**Modification to Eastern Creek Business Hub
Concept Plan (SSD-5175-MOD-5) and Retail Centre Lot 1 (SSD-8858)**

SCHEDULE 1

SSD 5175 MOD 5

SSD 8858

8.8m MEDIUM RIGID VEHICLE
SWEPT PATHS

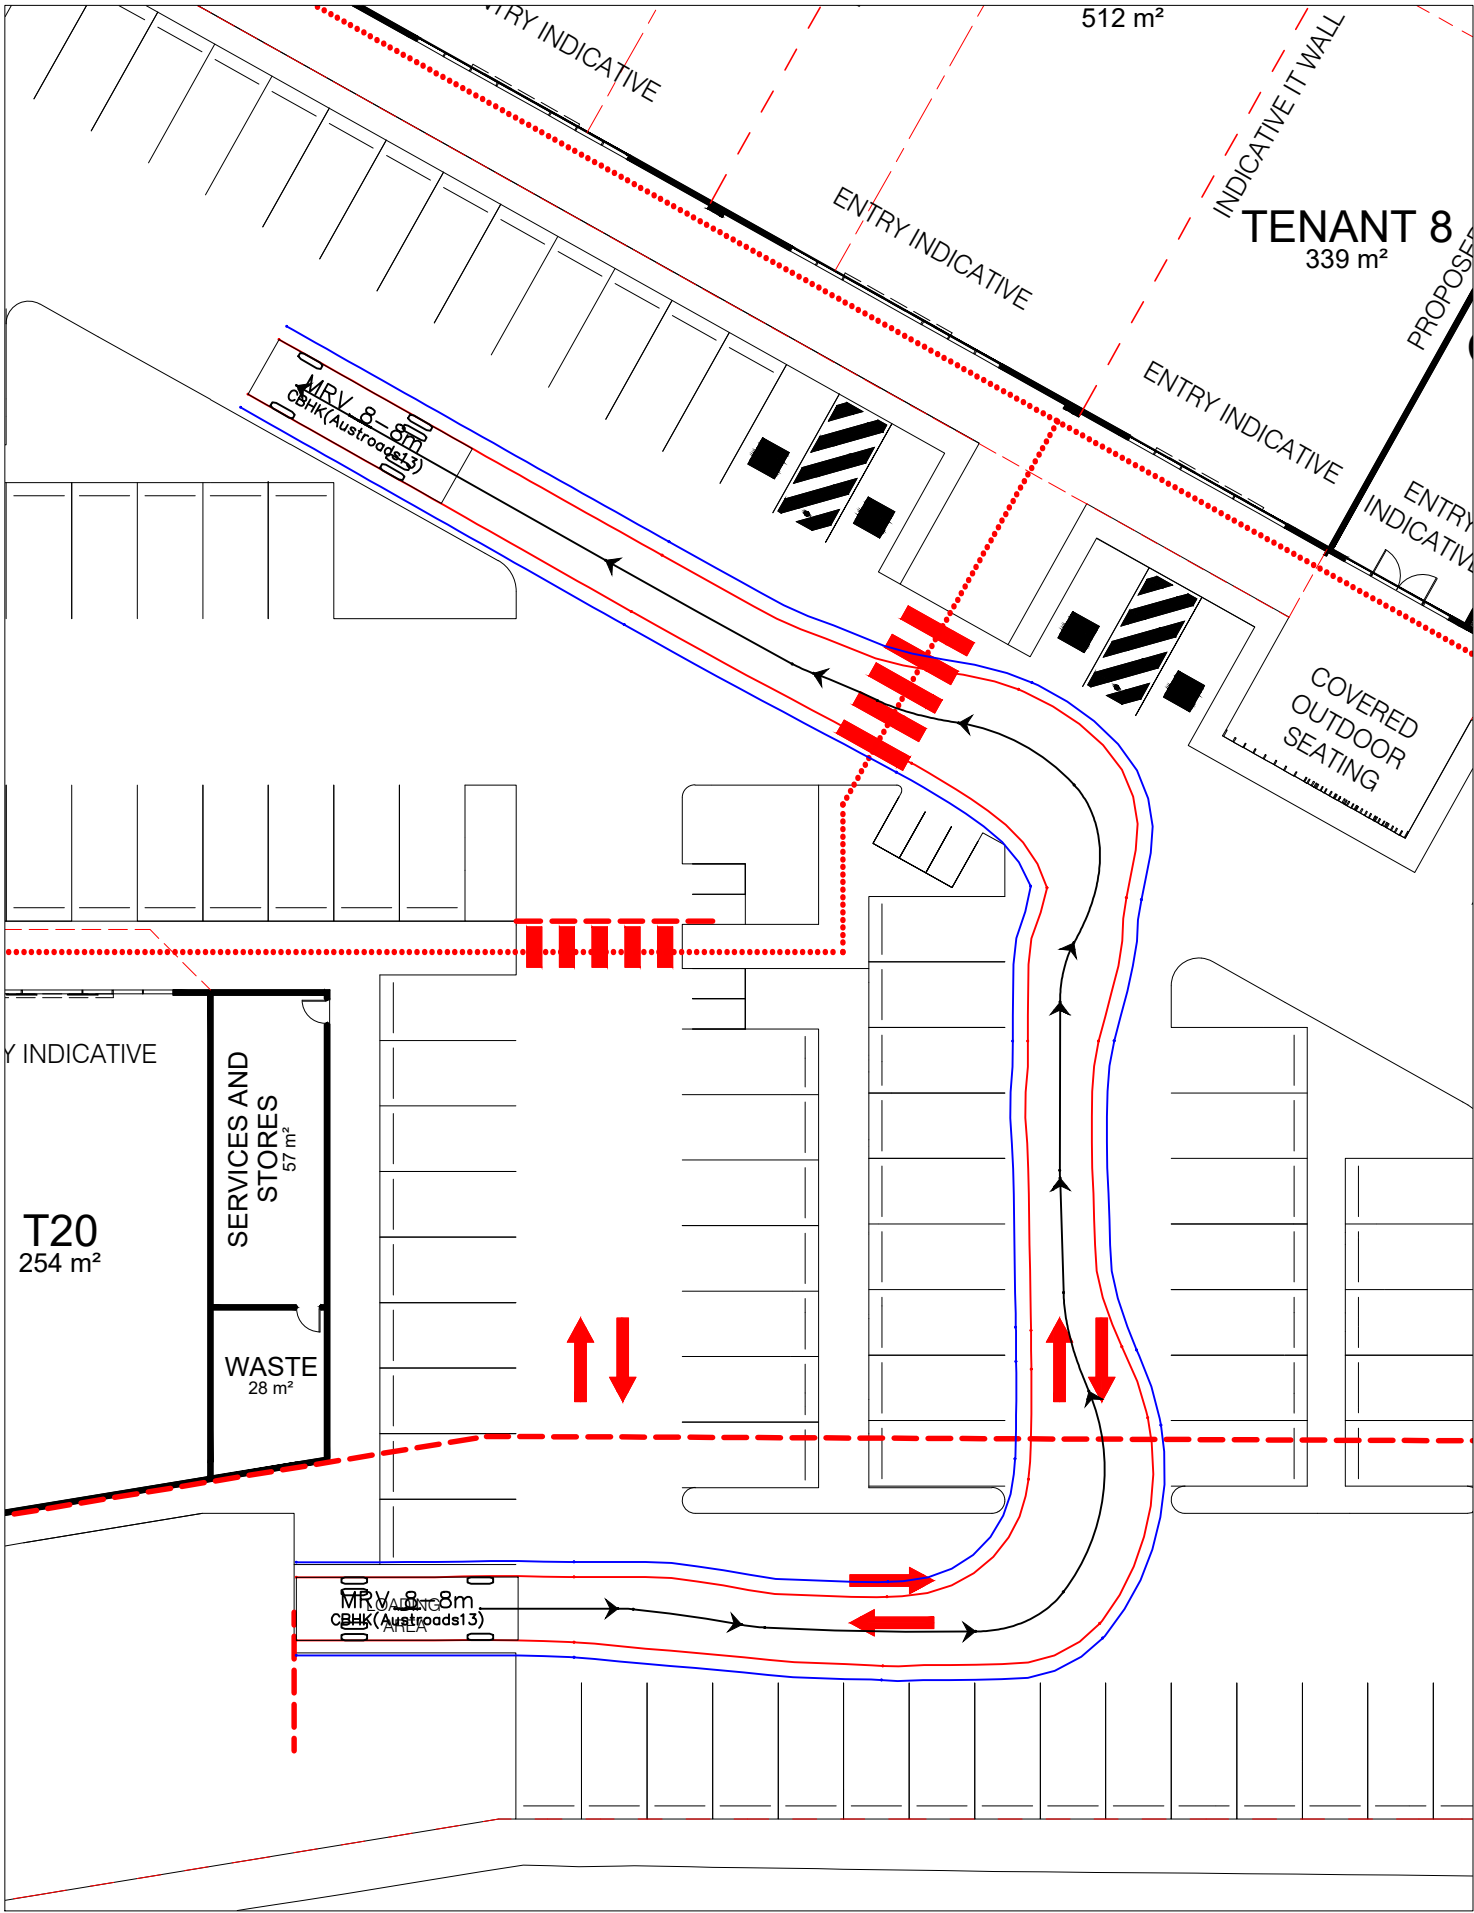
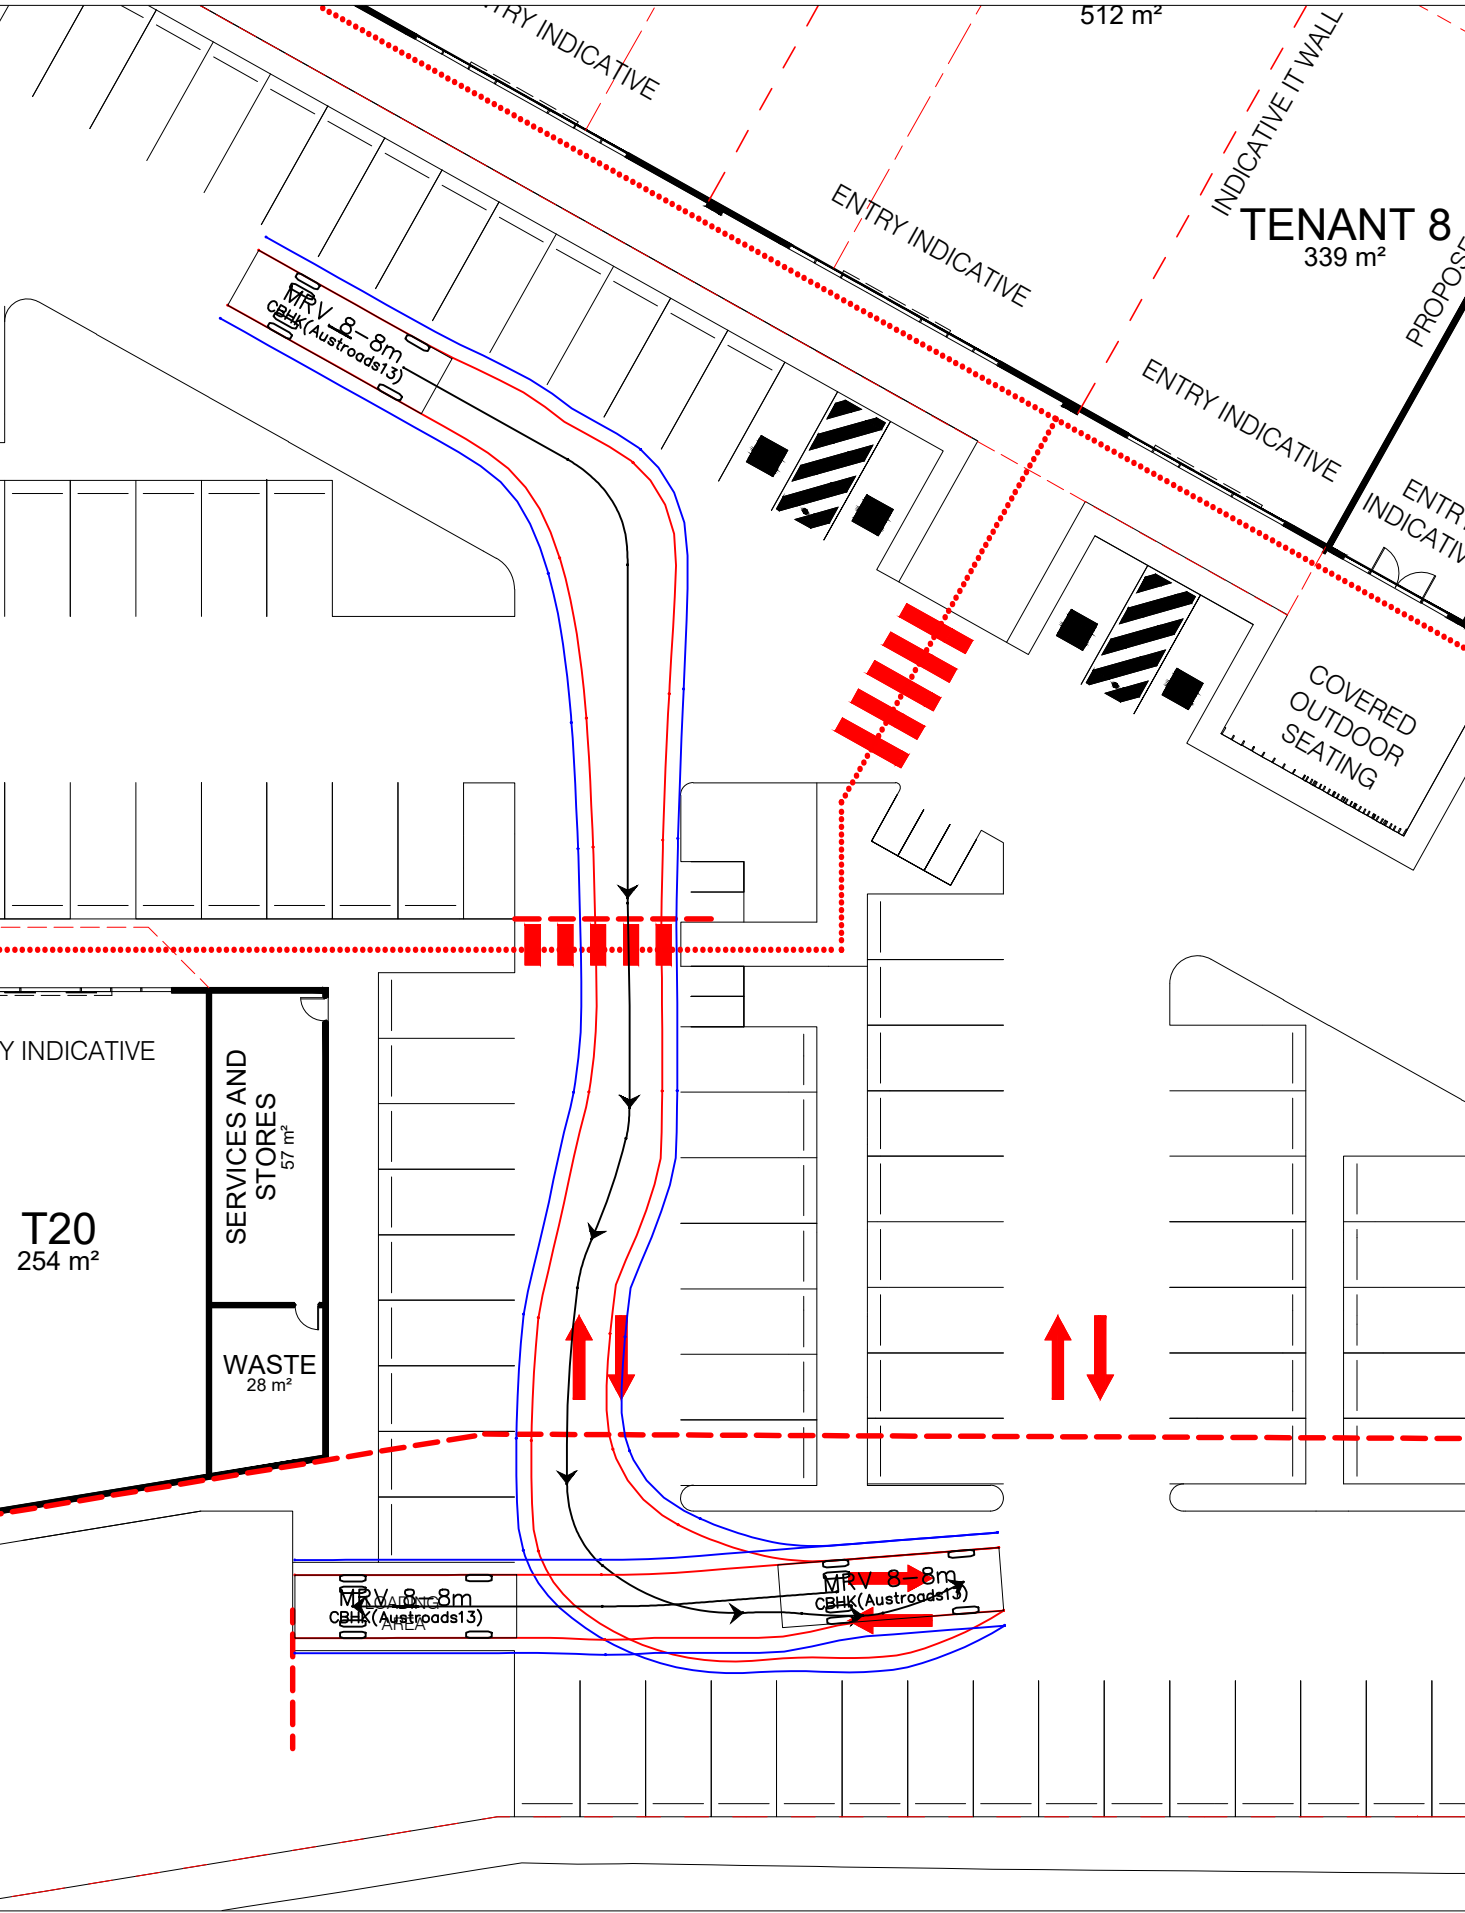
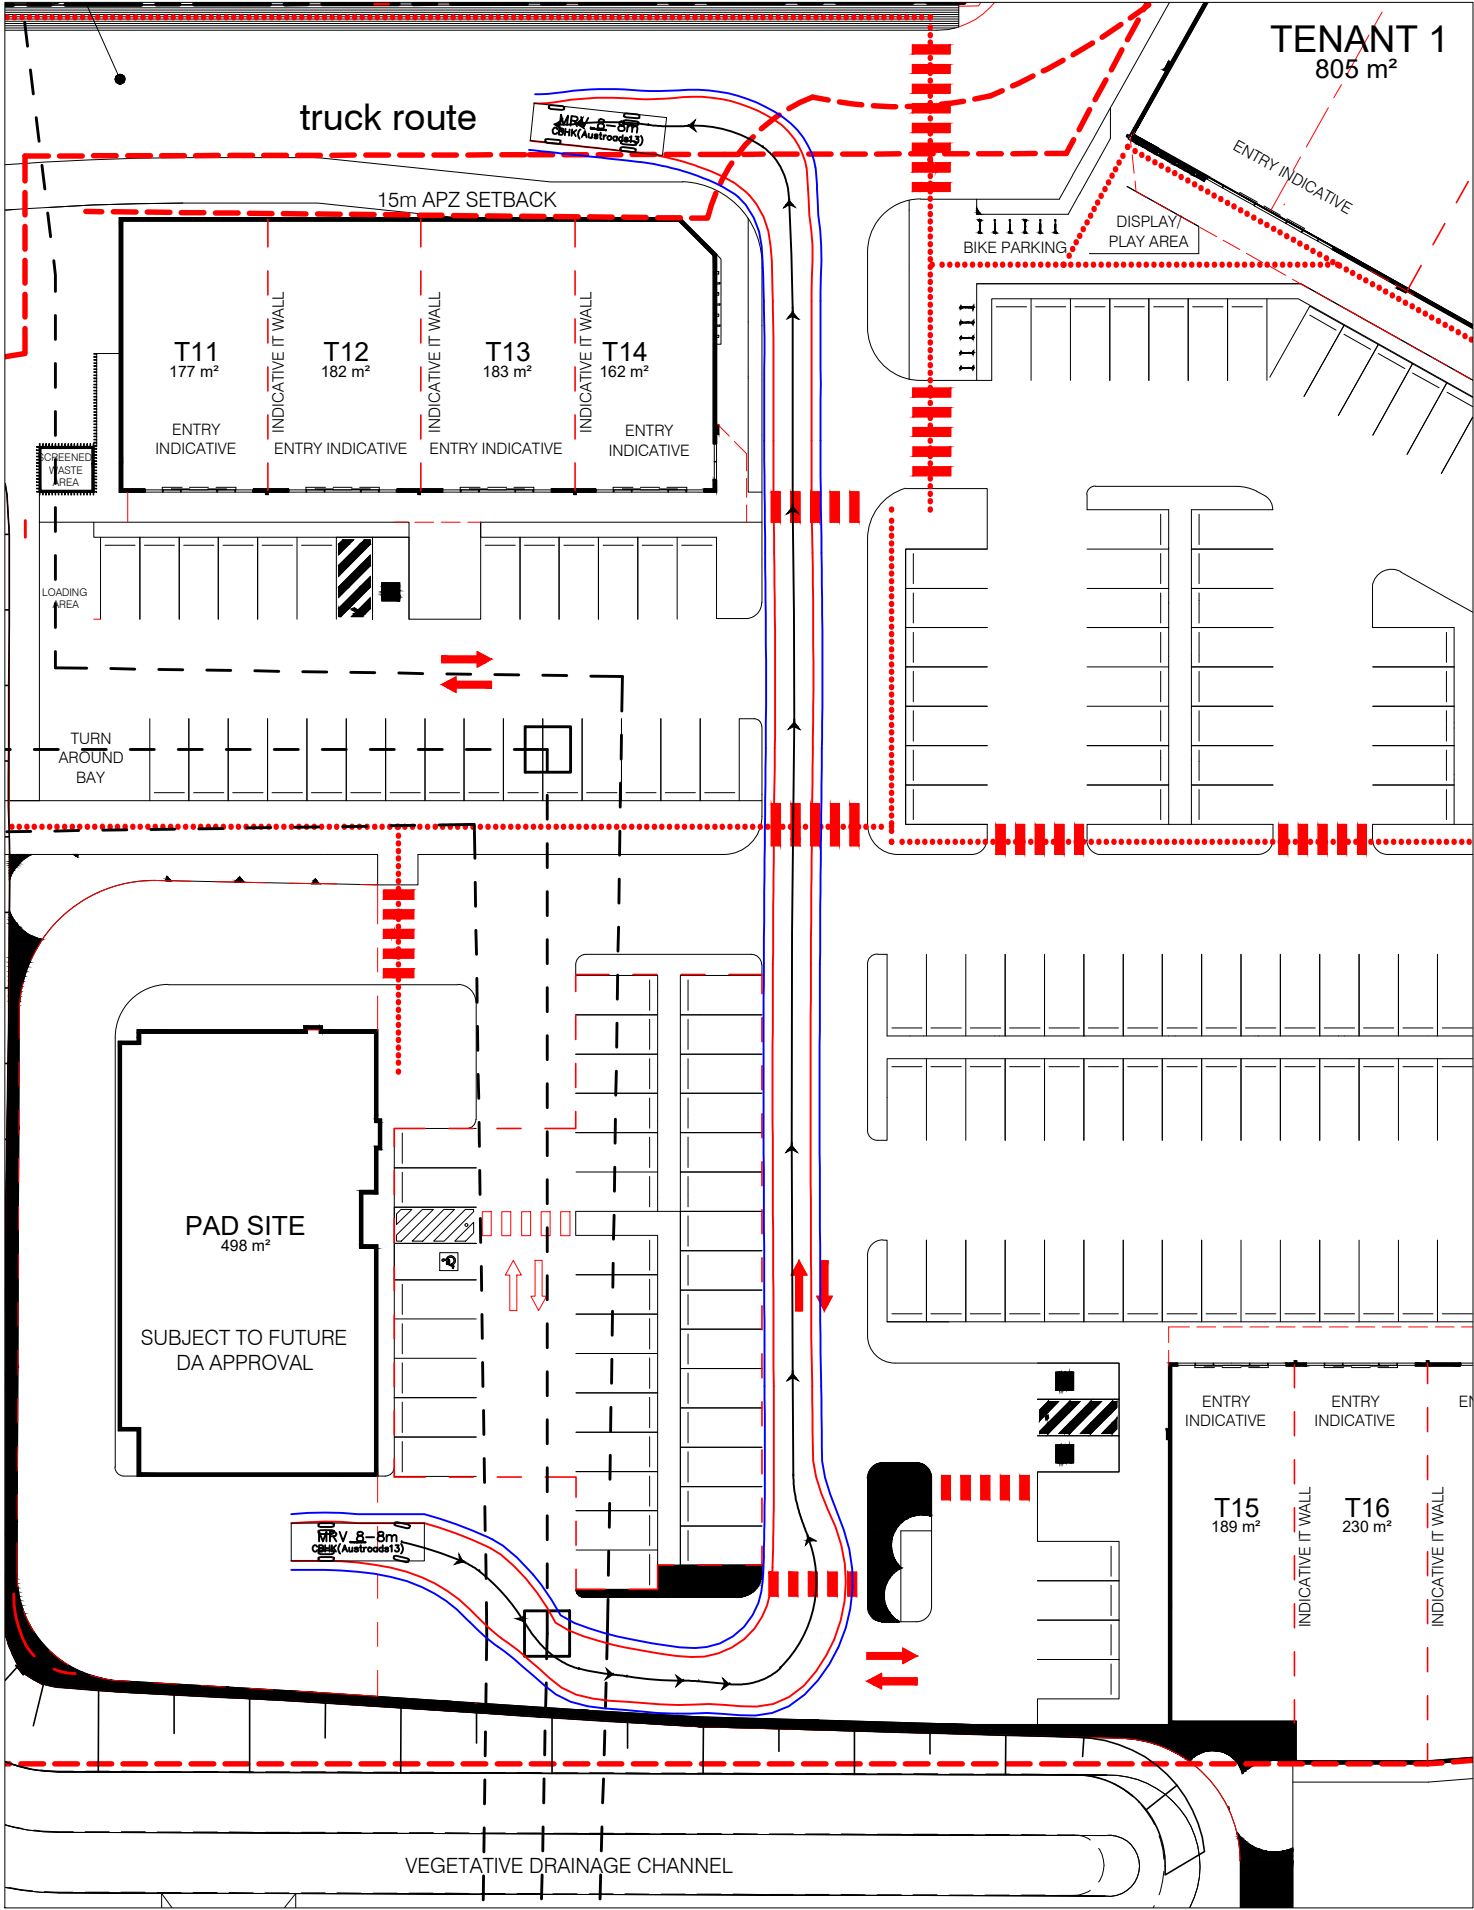
Clarify the arrangements for loading and unloading for buildings 2, 3 and the pad site. In particular:

- the inconsistencies in the RtS and the Operational Management Plan. The RtS notes smaller service vehicles will service buildings 2, 3 and the pad site outside operating hours. However, the proposed delivery hours are 7am to 10pm. In addition, the Operational Management Plan indicates deliveries will be completed by 5pm on Sundays.
- indicate where the smaller service vehicles will park and demonstrate there is sufficient space for these vehicles to manoeuvre within the carpark.
